**Consultation Response from KC,
Trees**

2024/92444 Land North of, Denby Lane, Grange Moor, Huddersfield, WF4 4BH

Erection of 21 dwellings and associated works with means of access from Denby Lane

Date Responded:08/05/2025

Date:	Feb 24	Project:	Denby Lane, Grange Moor
Scale @ AS:	1:500	Drawing Number:	Site layout
Drawn By:	CD	Revision:	T

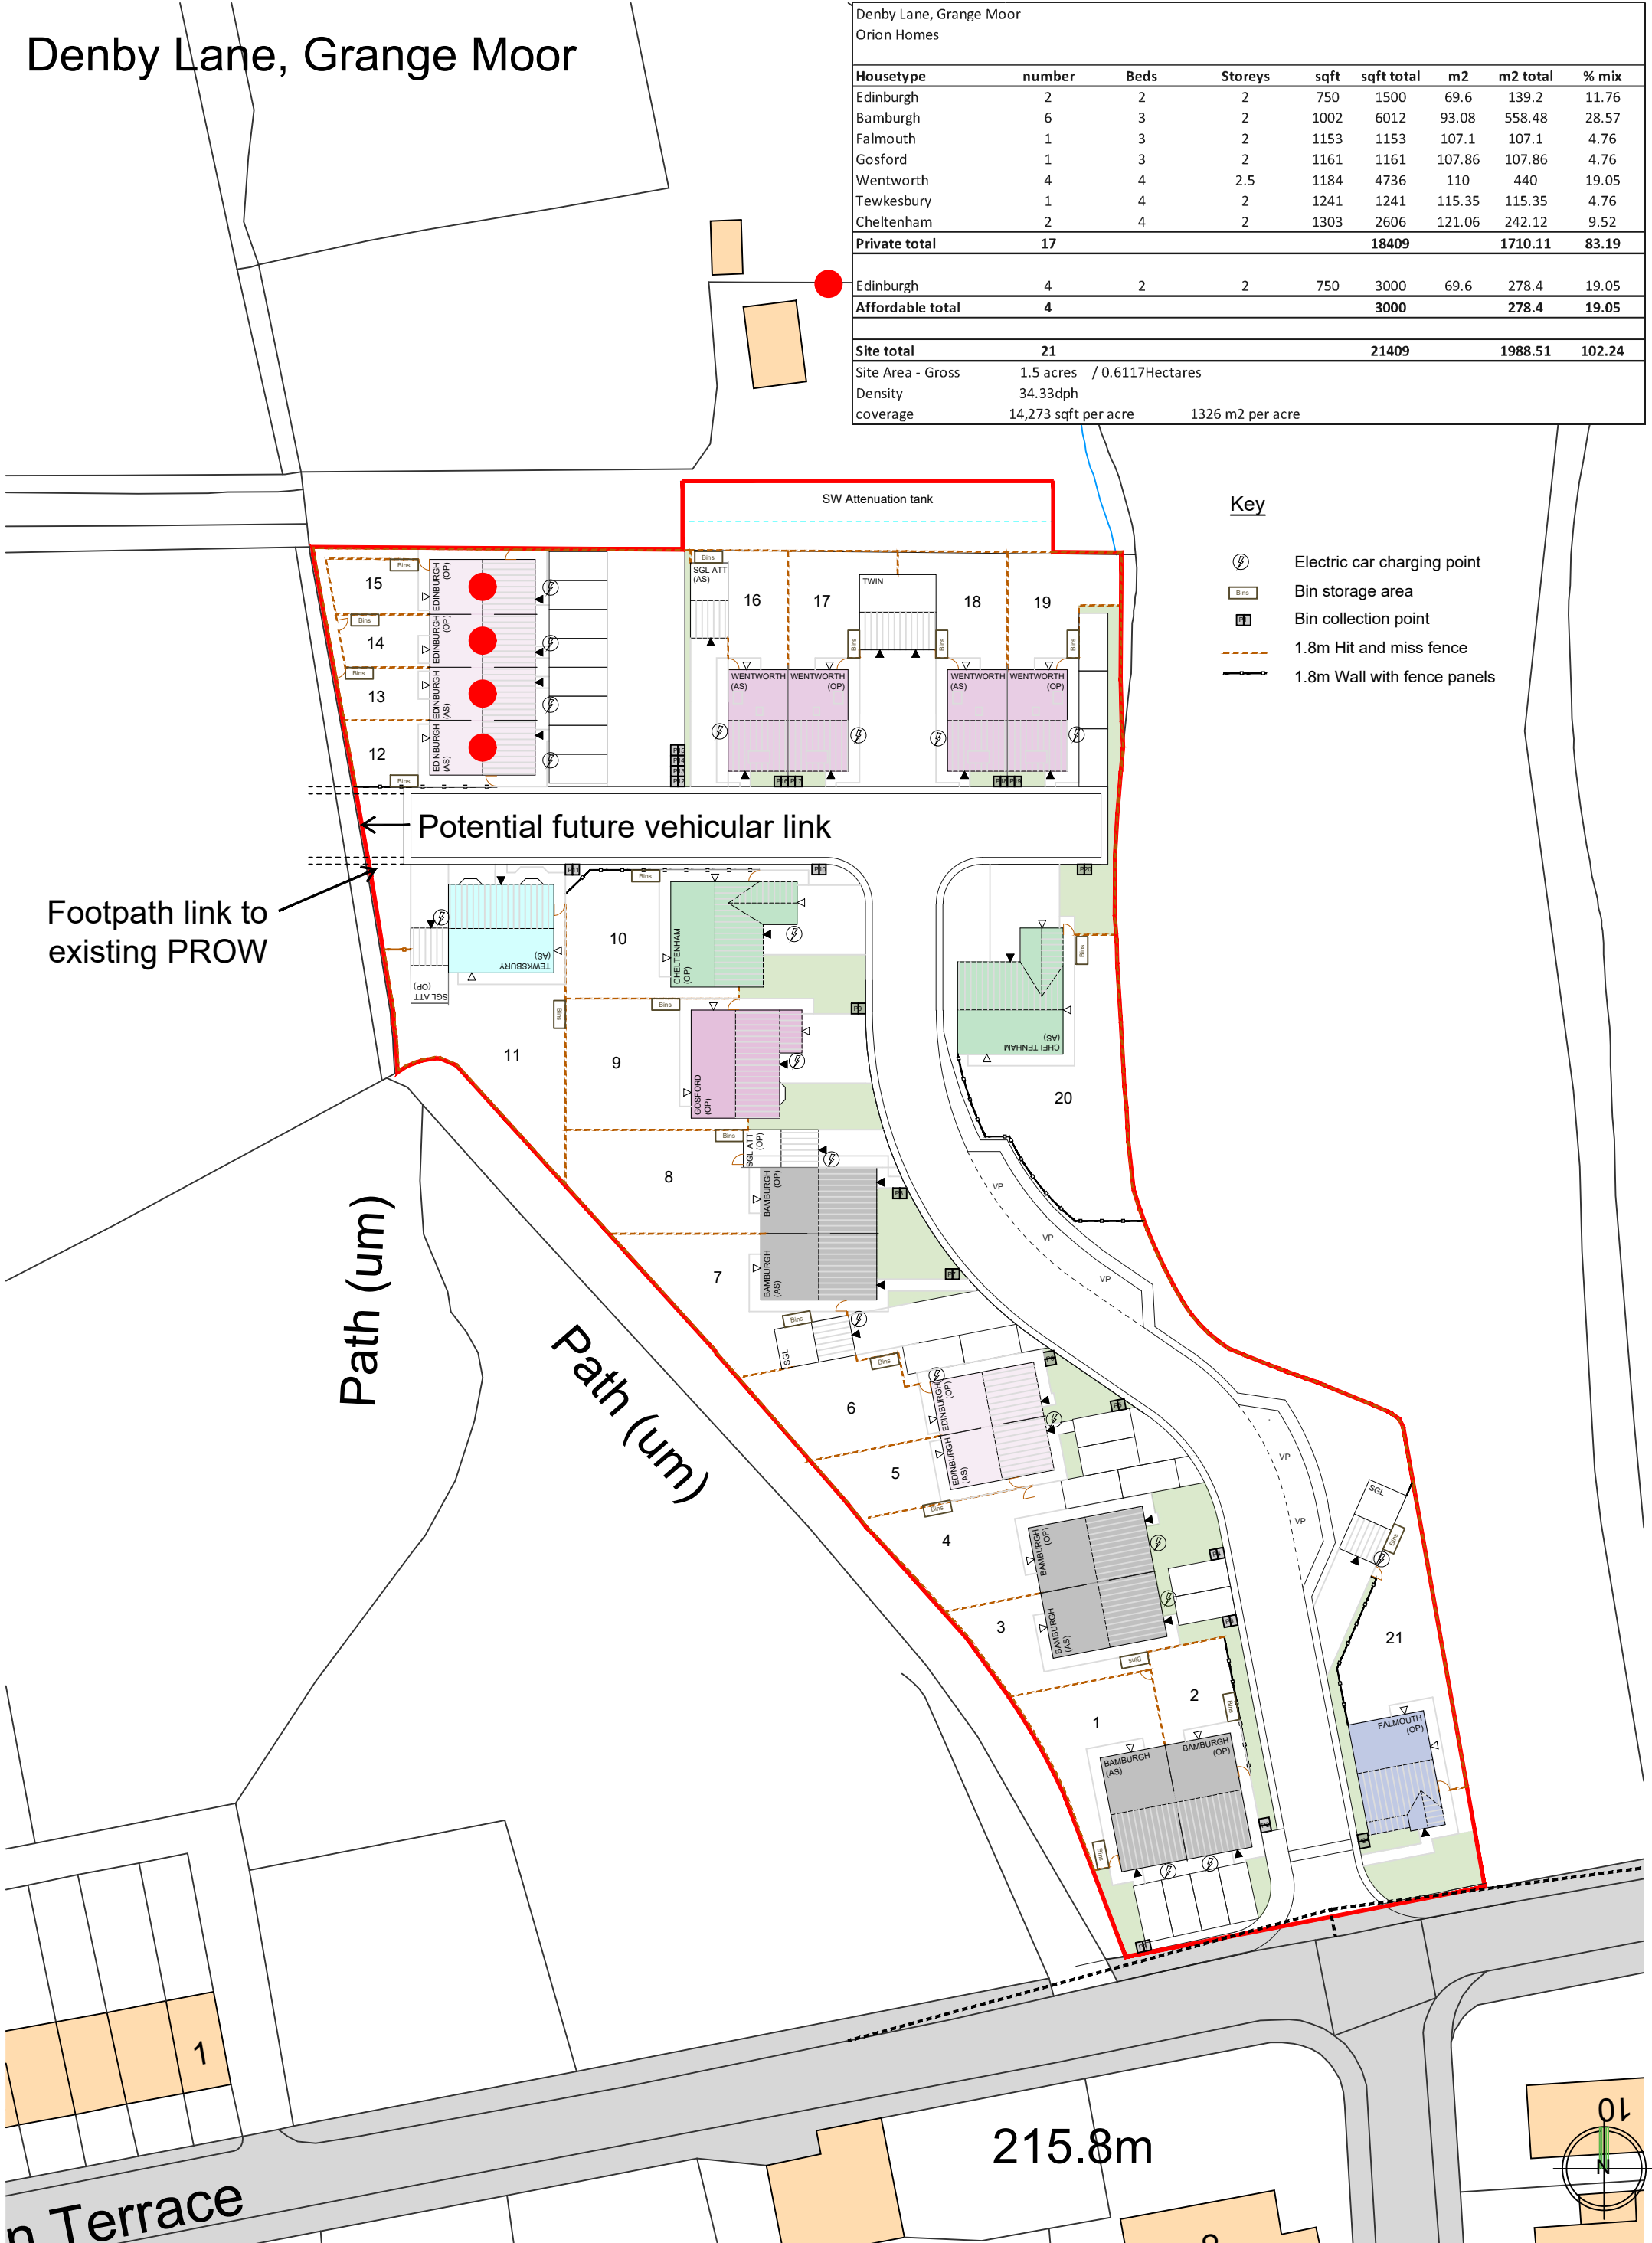
The new layout has been reviewed (Rev U). Plot 21 is placed 1.5m further away from site boundary to allow additional space between the building and the adjacent Category B semi-mature woodland G02.

This is a welcome revision which will reduce the pressure of the development on the adjacent semi-mature woodland, and likewise reduce the nuisance associated with the proximity to trees on the future property owner.

The AMS should demonstrate how all retained trees will be protected throughout the development of the site and include a no-dig construction methodology for the proposed footpath which passes around the rear gardens of Plots 14 and 15 to minimise impacts to G03.

From an arboricultural perspective there are no objections, subject to the receipt and approval of an AMS and planting scheme, which may be secured via condition.
